↳ Respond to BUILDING DEPARTMENT COMMENTS.
CHANGES TO PLANS OR DETAILS BROUGHT ABOUT DO TO
REVIEW ARE SHOWN CIRCLED WITHIN.

PROJECT

LANIER - PFEESER

019-124

SECTION #53

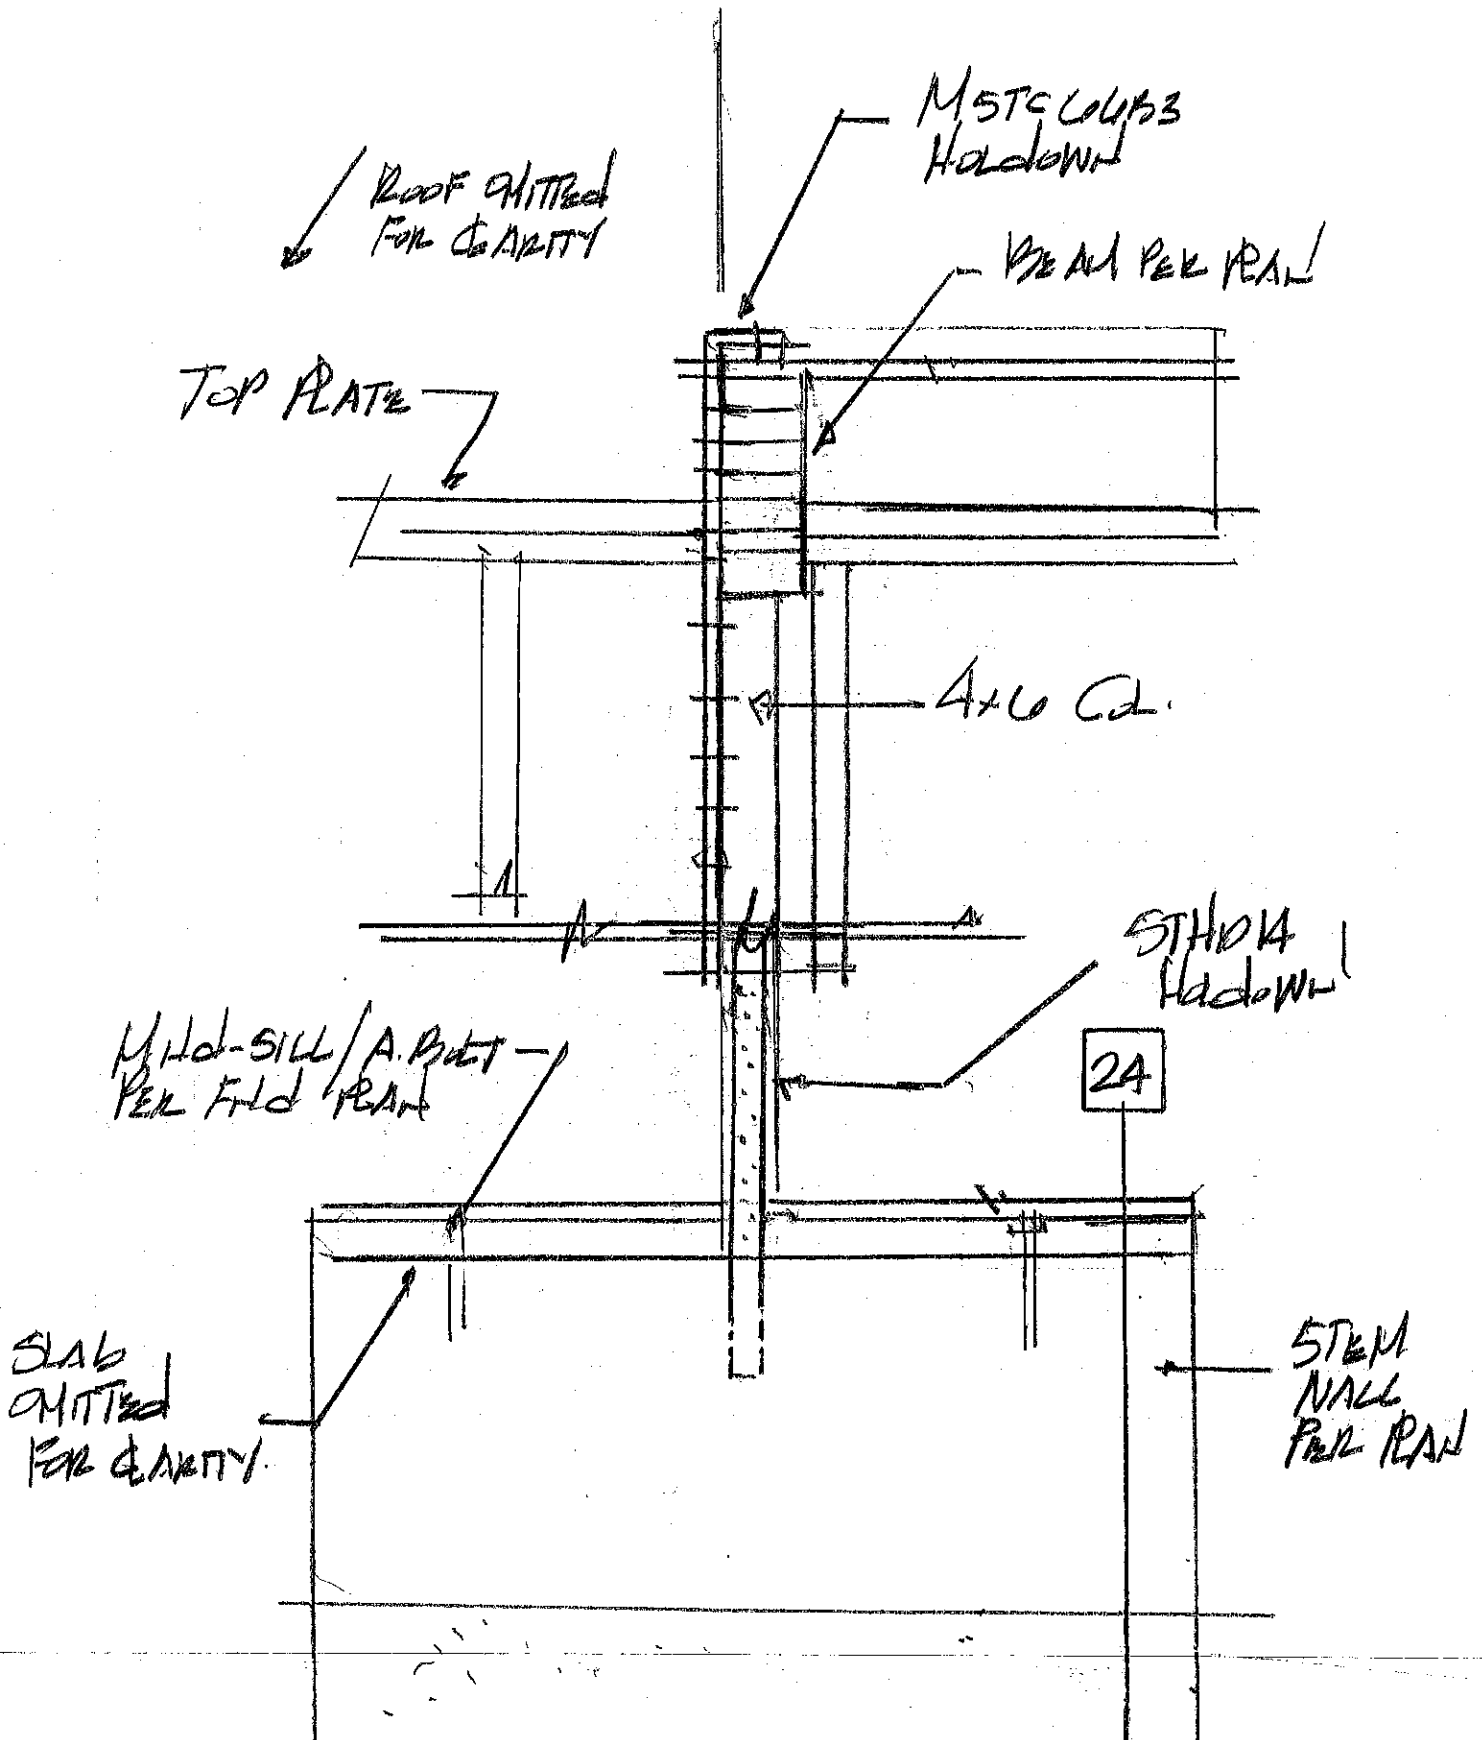
COMMENT #13:

SECTION # 53 CUT OUT PANEL

SHEET A-10
OF 17 SHEETS

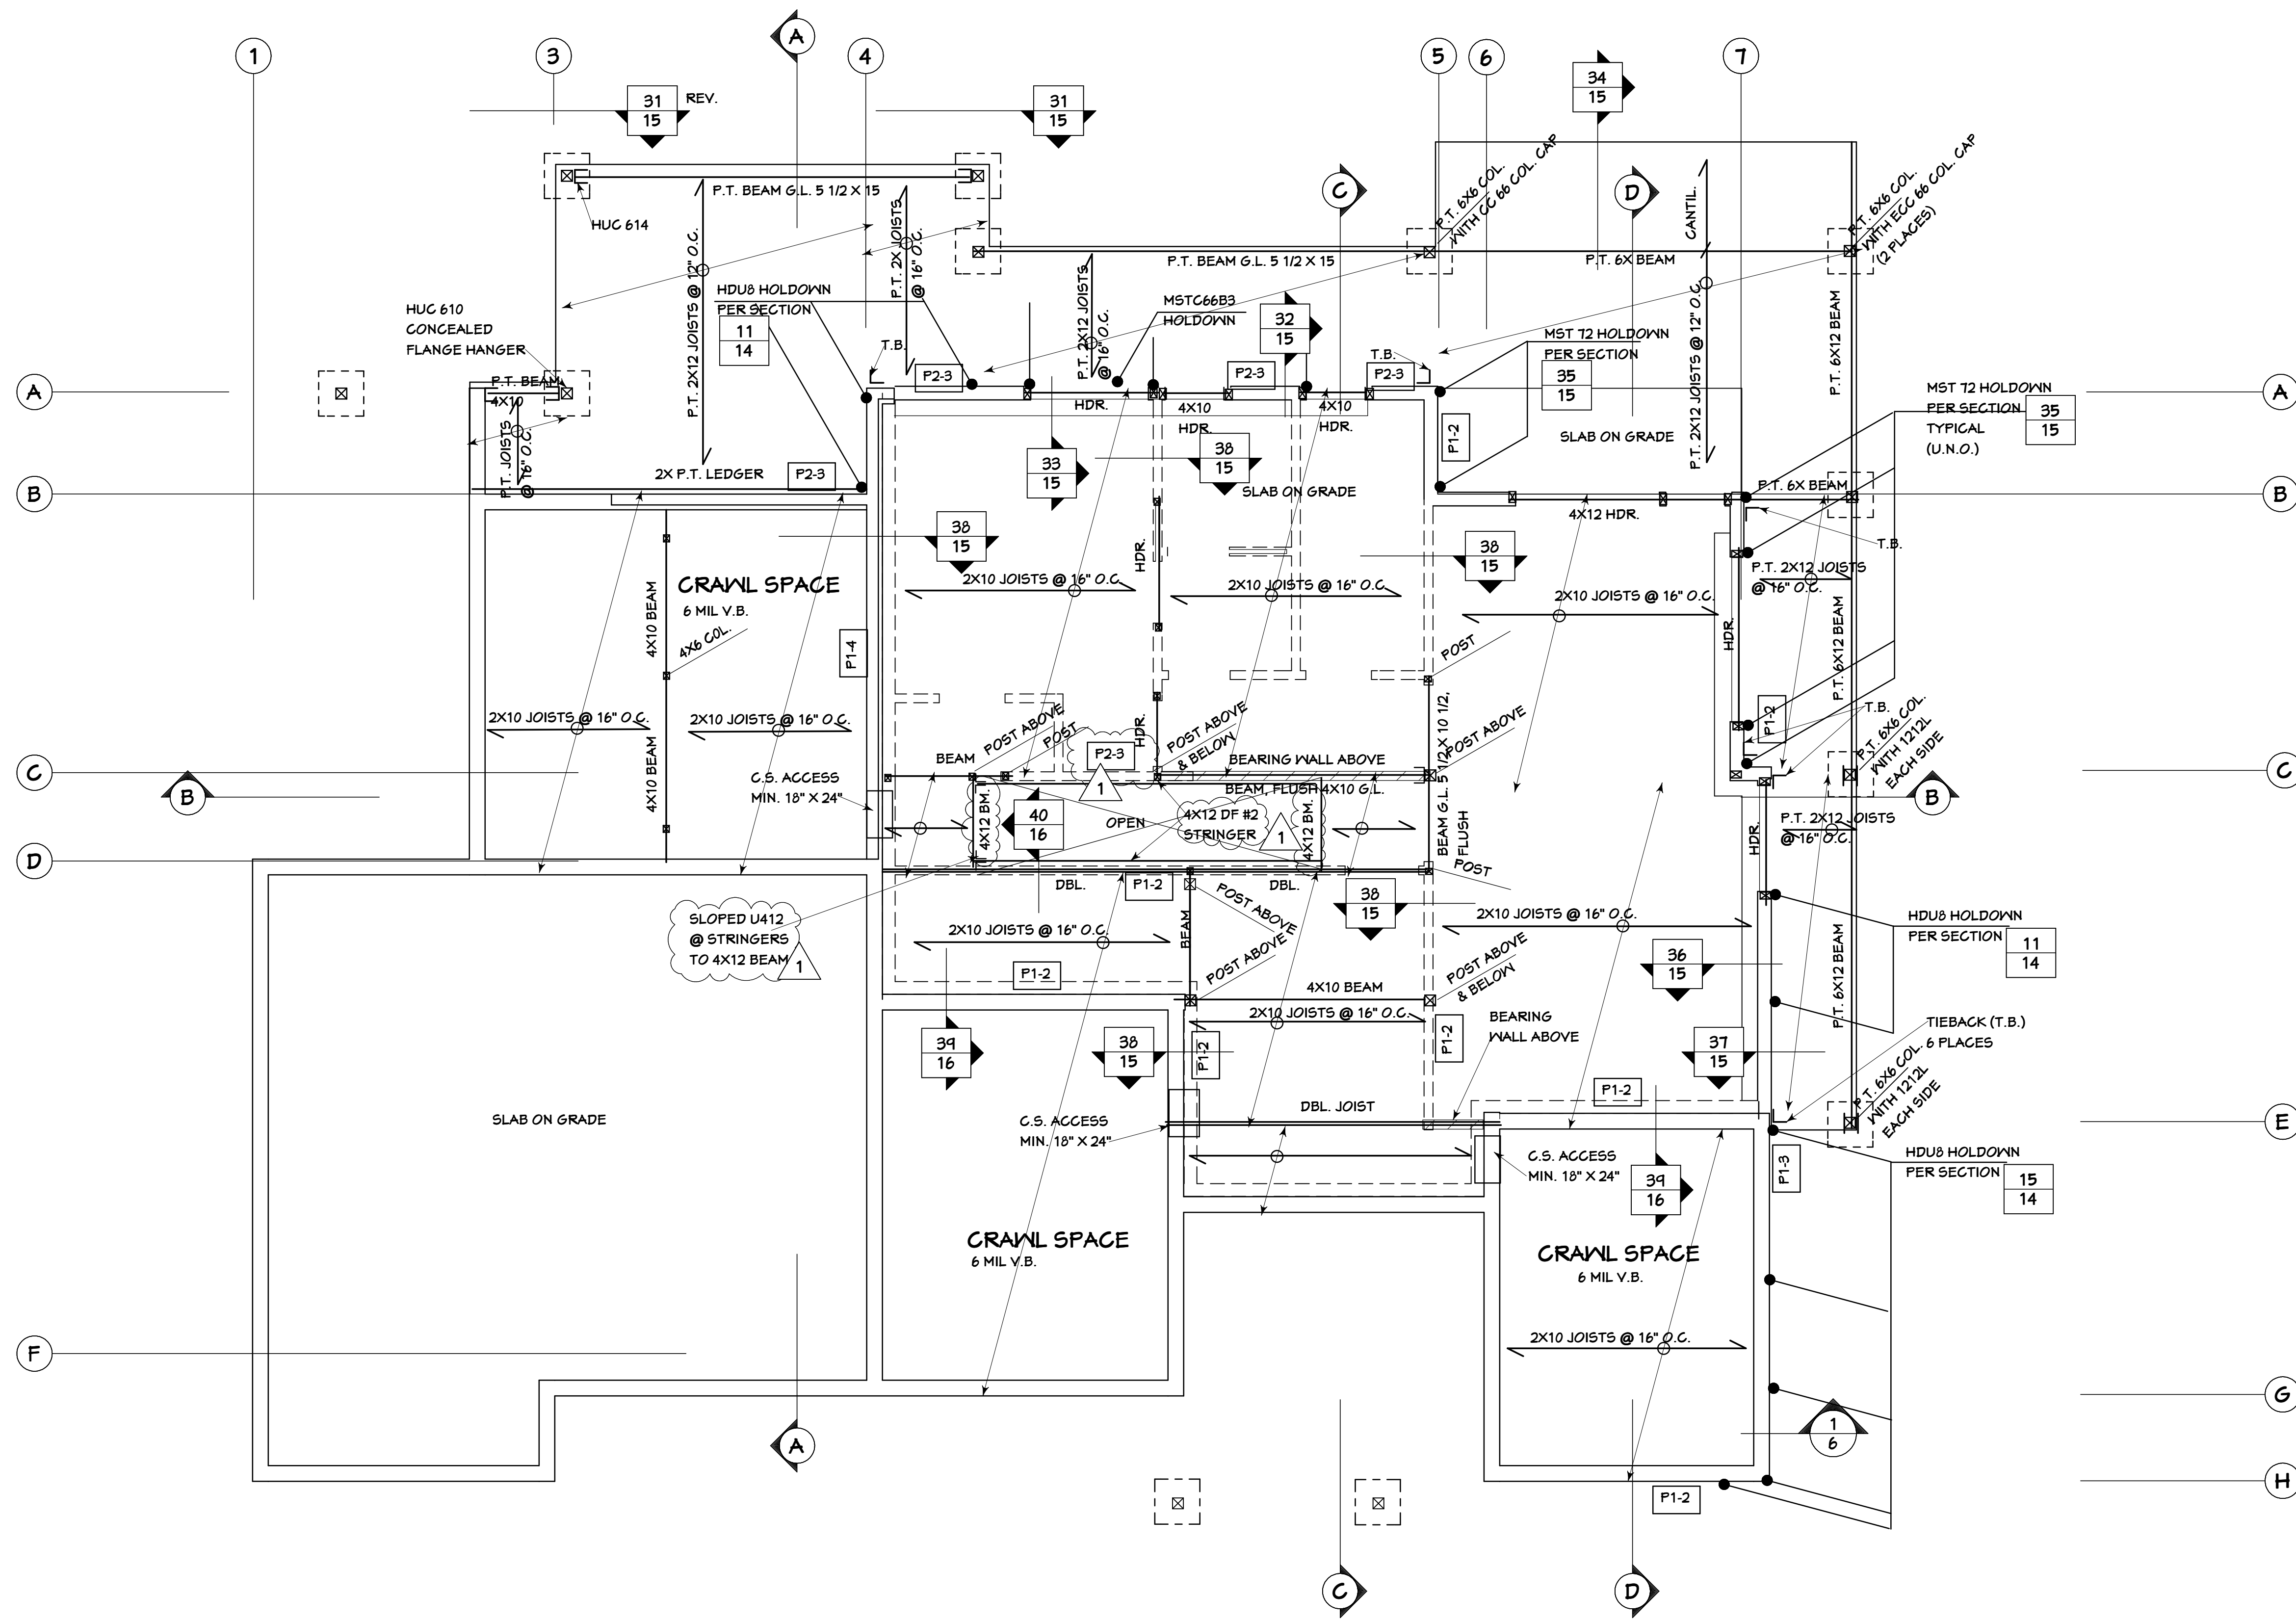
COMMENT #3:

↳ USE WALL @ GRID (C)
√ → 200 PF + 19' = 3910' / 0.5' = 002 - P2.3
1.3910' / 0' = 0510' - ADD HOLD

COMMENT #5:

WALLS USED IN THE DESIGN HAVE A HOLDDOWN
ON EACH END THE OTHER WALLS ARE REDUNDANT
WALLS NOT USED IN THE DESIGN.
